## Wicklow County Council

RE: Referral Ref. ABP 320327-24

I refer to your letter of the 06/08/24 in relation to the above mentioned Referral. The Planning Authority considers that its reasons and considerations in relation to the submitted S5 Declaration Request are fully set out in its planning report and Declaration previously forwarded to the Board. However, the Planning Authority would like, in the interests of clarification, to comment on the submitted Referral as follows.

3 02 Rear Elevation
1 : 100

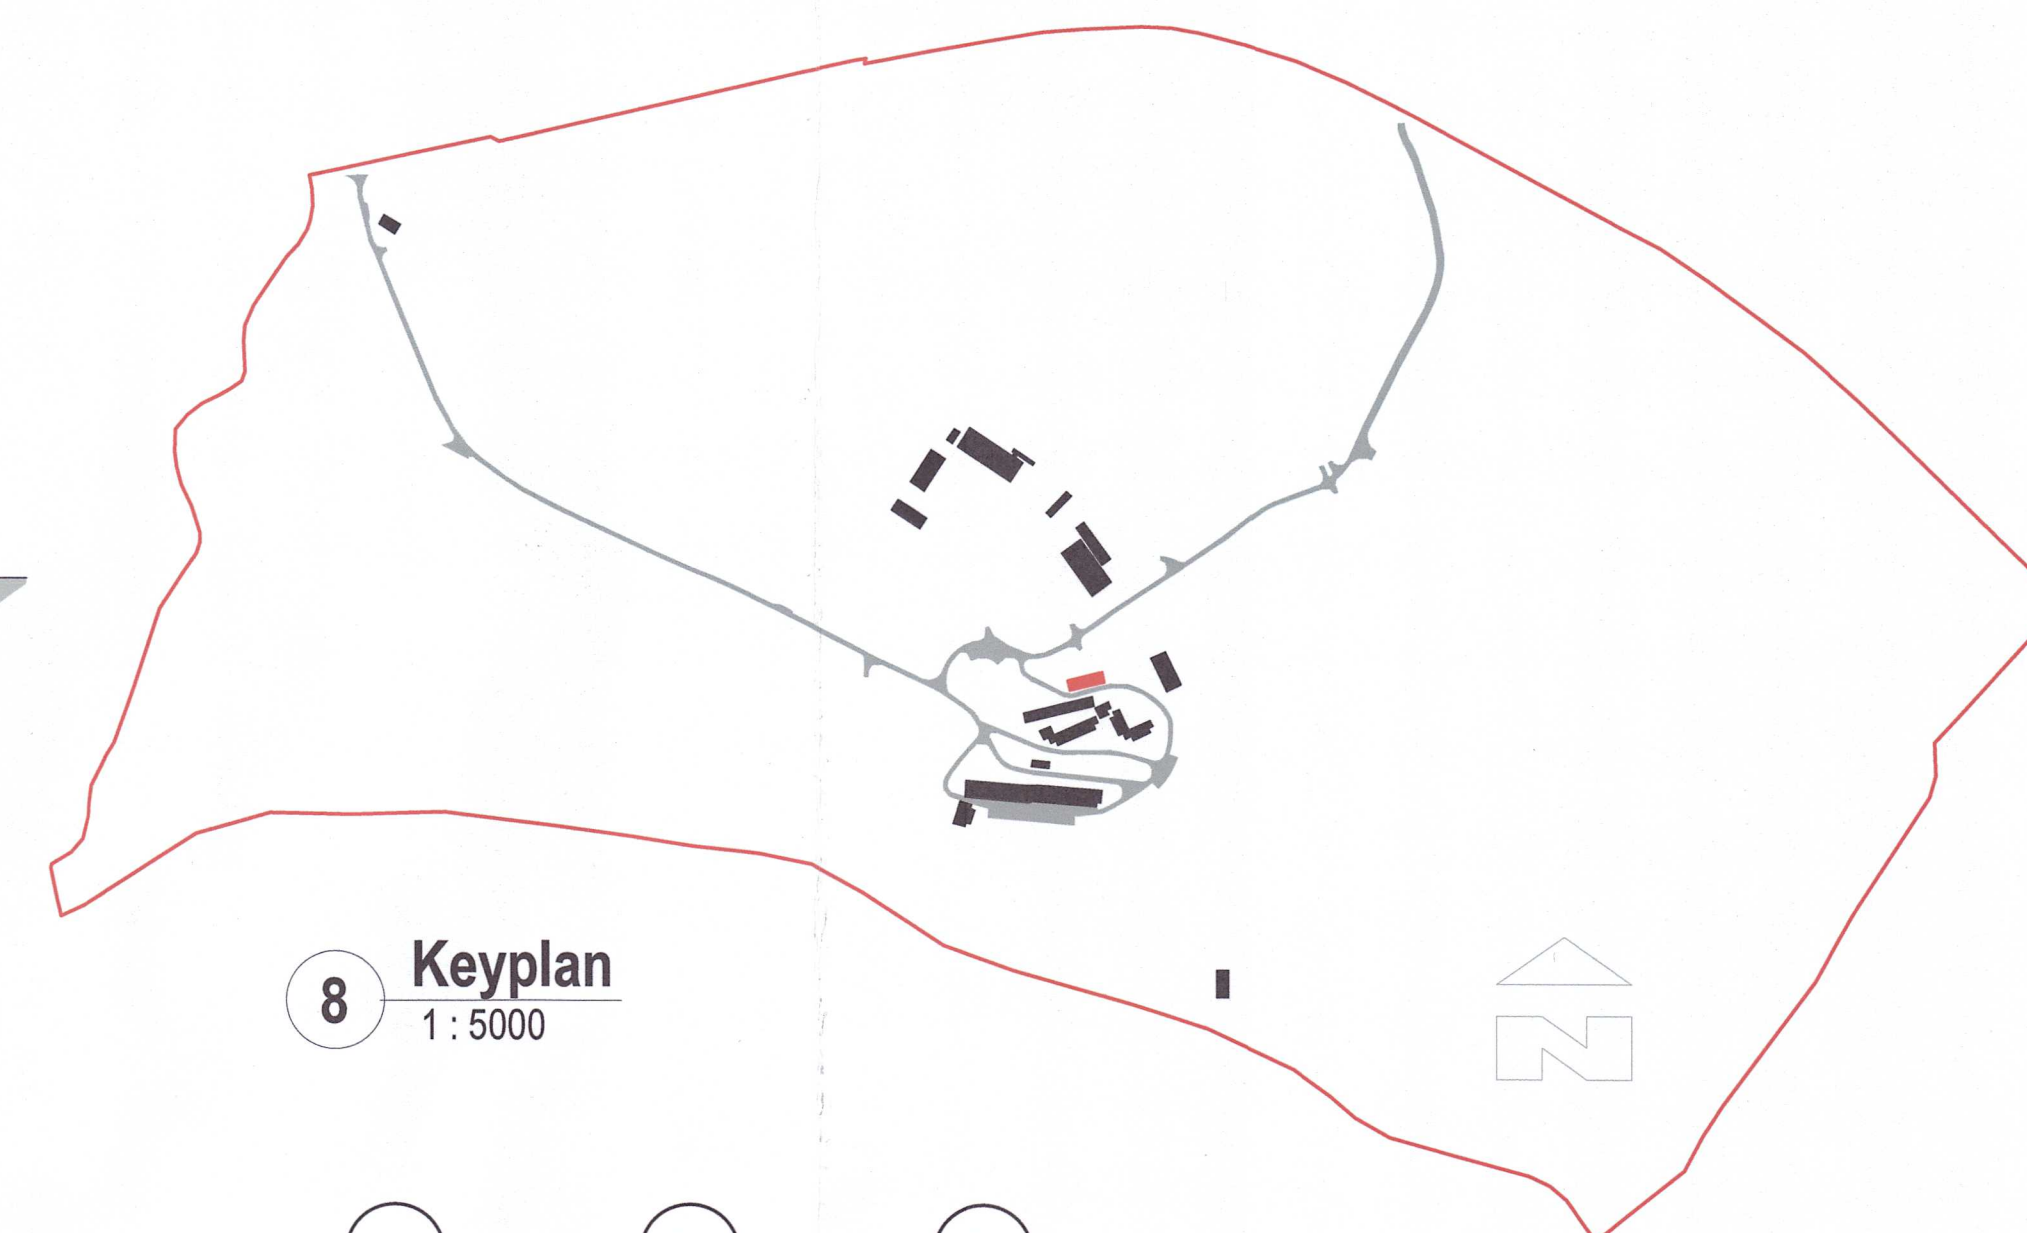
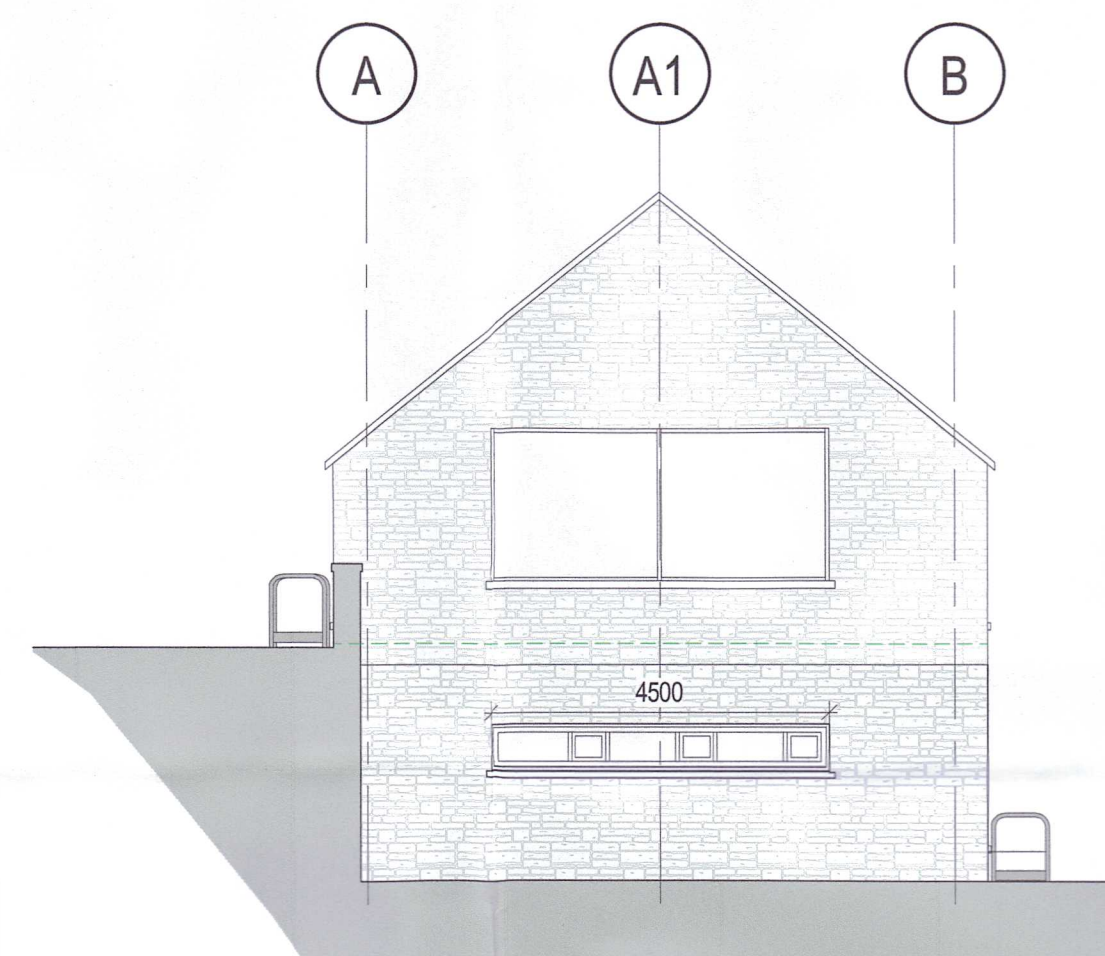
The Planning Authority, as it is entitled to do, determined that Structure No. 10 was significantly altered such that it was now inconsistent with the character of the original structure. There is no requirement to assess what the perspective of 03<sup>rd</sup> Parties from the public domain would be.

It also determined that the significant alterations did not come within the scope of S4 (1) (h).

Structure 12 - Plans,
Elevations & Section

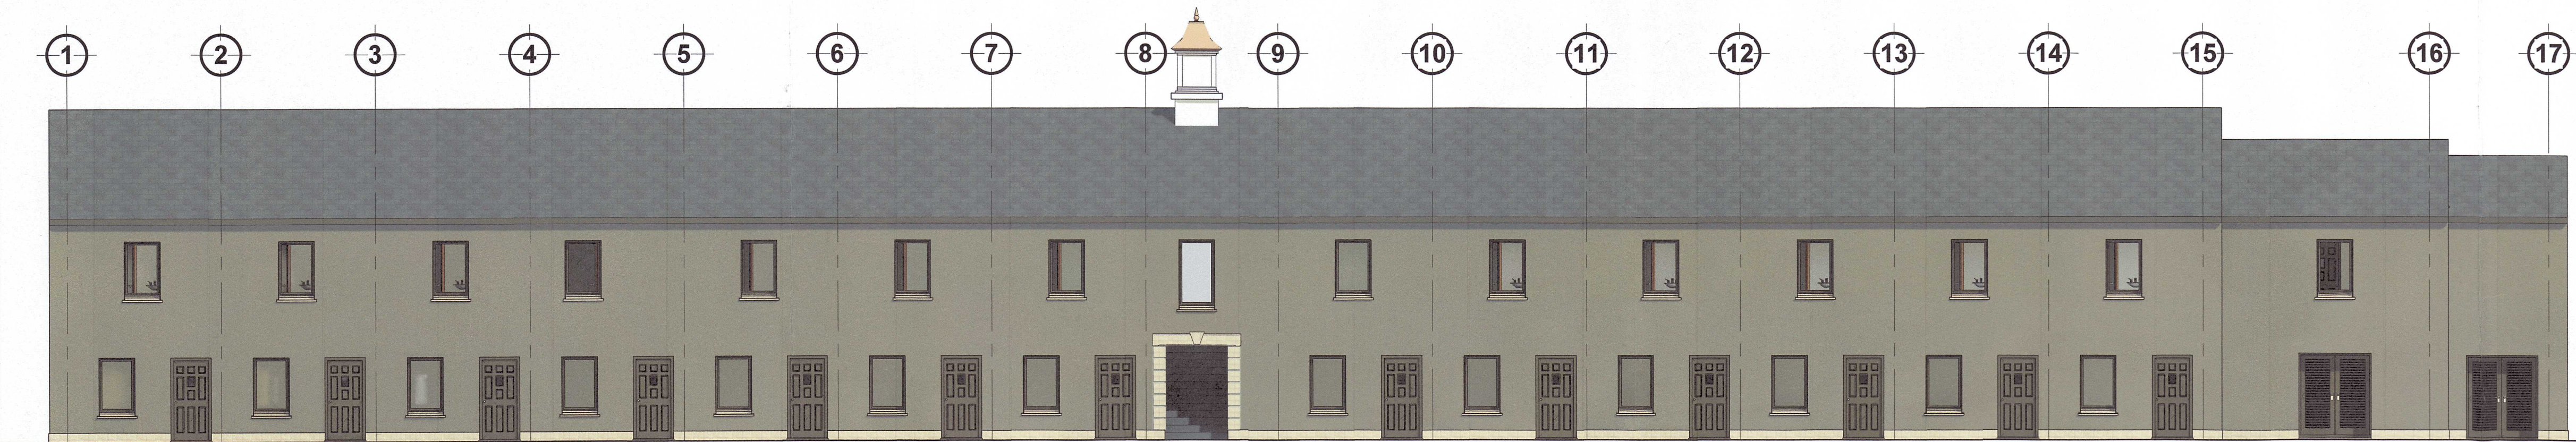
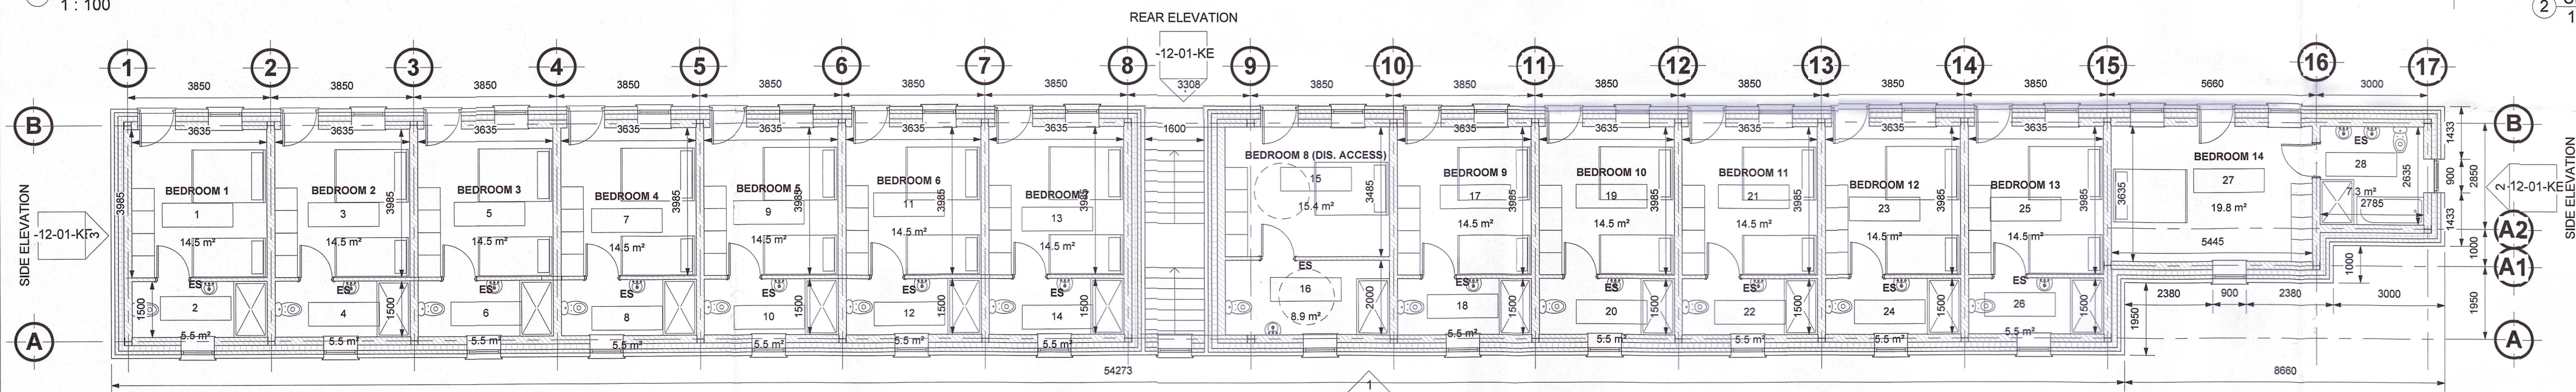
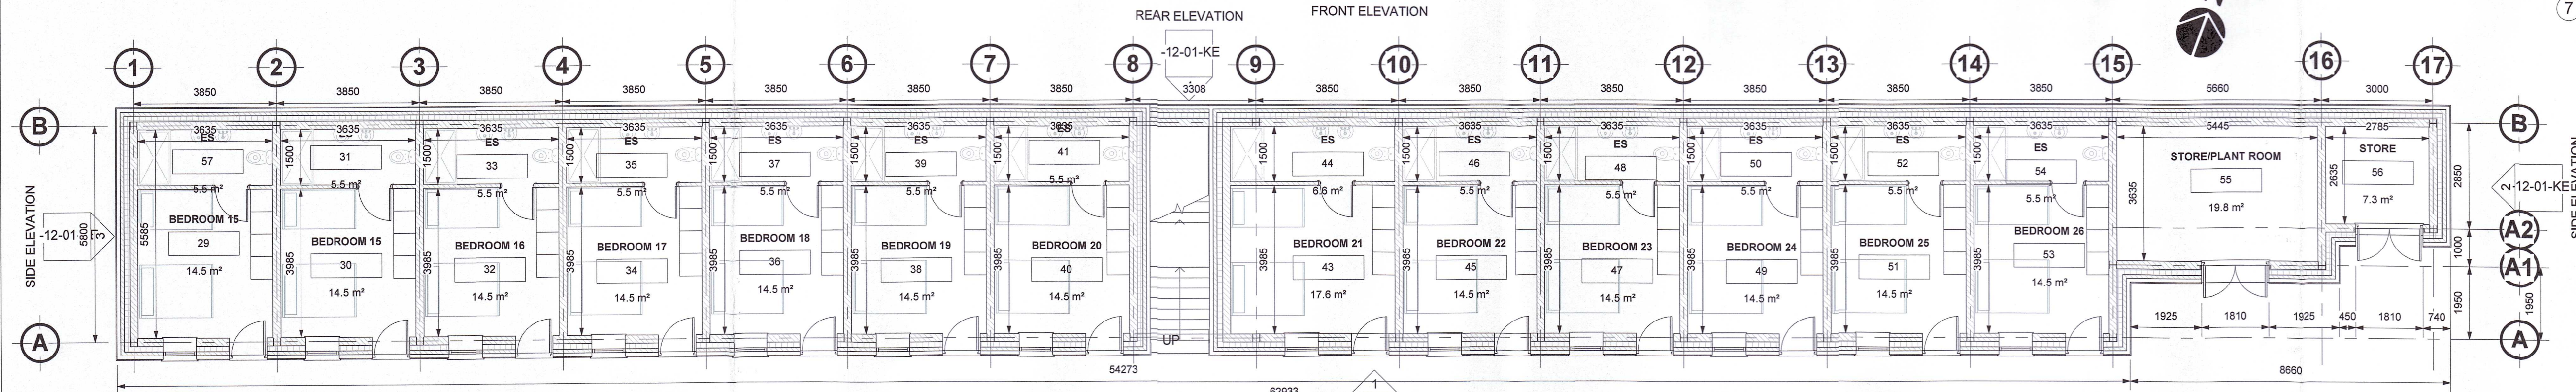
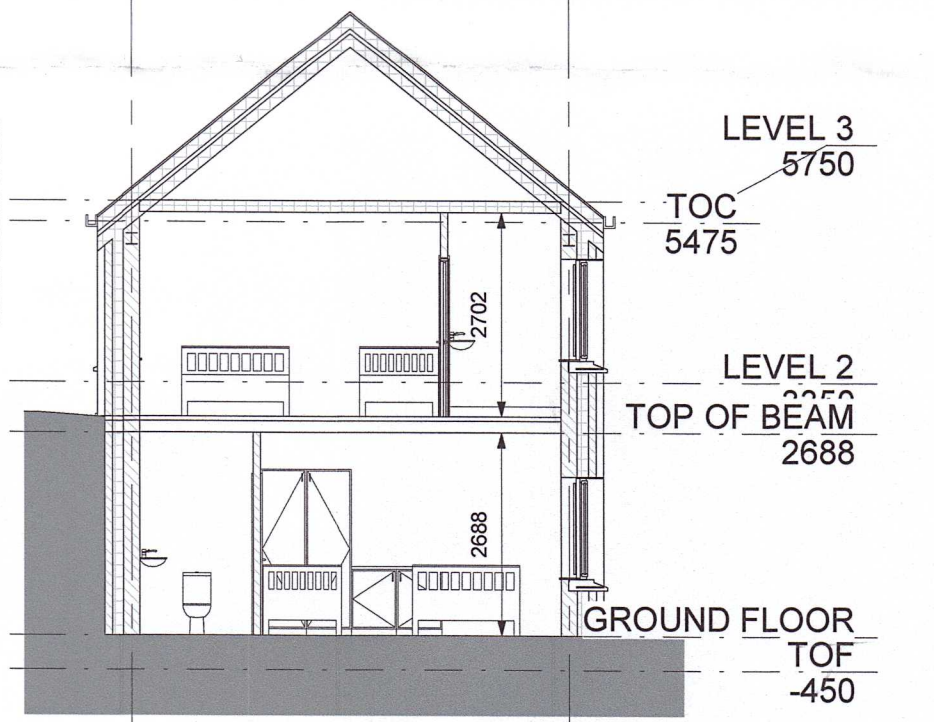
It is noted that no evidence/detailed information has been provided in relation to the statement of the Referrer that "This building complex was known on the estate as the 'long barn' and had various uses, renovations and alterations down the years", nor any commentary as to the planning status of the uses, renovations and alterations down the years

It is also noted that no detailed drawings, etc., have been provided to accurately describe the original pre '64 structure and the alterations stated to have been undertaken. From its analysis the Planning Authority concluded that the existing structure was significantly different in terms of size, scale and location.

It was also noted in the Planning Authority's report that no evidence had been provided that the construction of this structure at the date of construction was being provided on behalf of a State Authority.

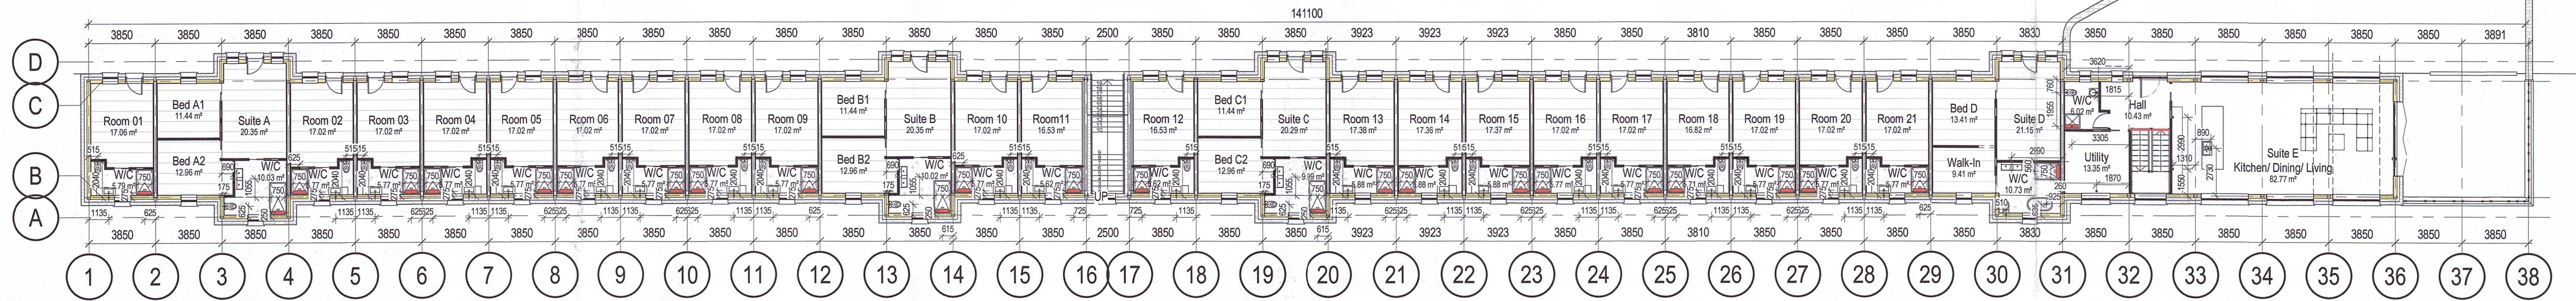
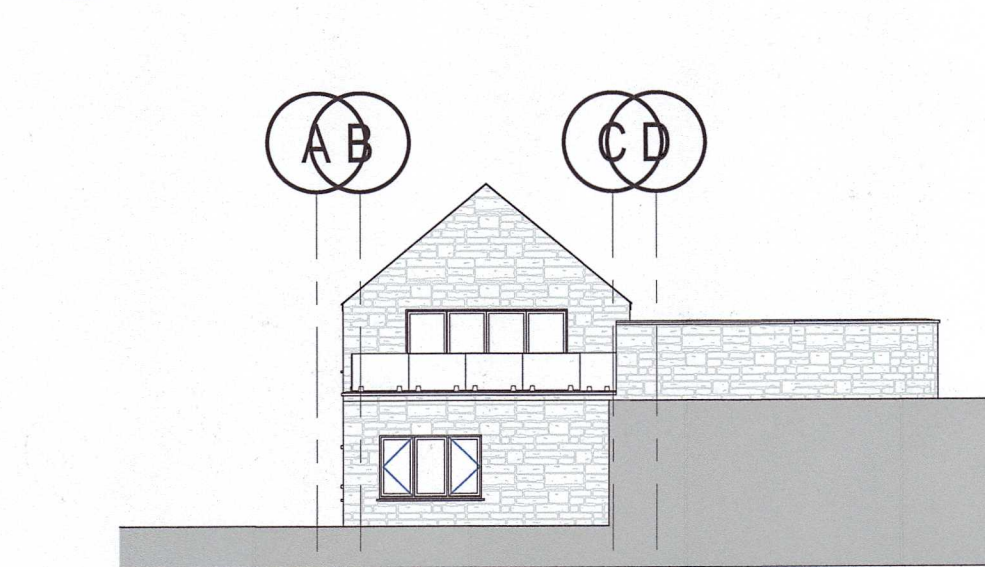
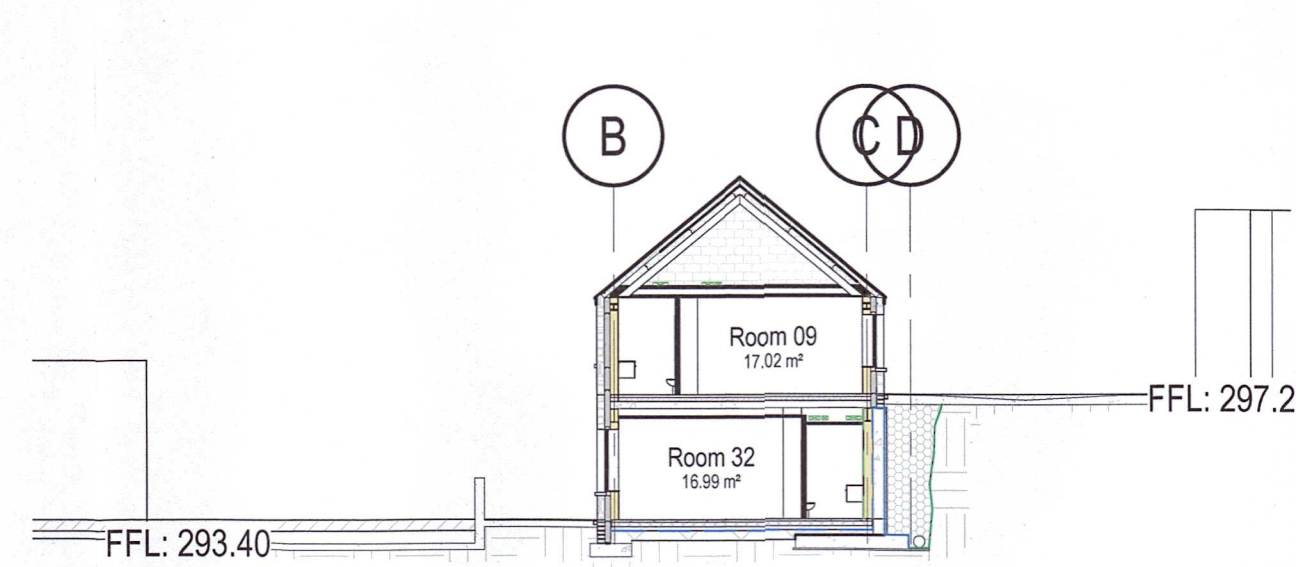
It is not clear how a temporary building whose principal components were manufactured off site can be considered to come within the scope of S4 (1) (h) for works carried out to what is stated to be a pre '64 structure.

It is noted that the Planning Authority did not include in its Declaration under its Main Reasons the fact it considered S4 (1) (h) did not apply to Structure No. 16. However, it did set this out in its planning report. The Board may wish to consider this when issuing its Declaration.
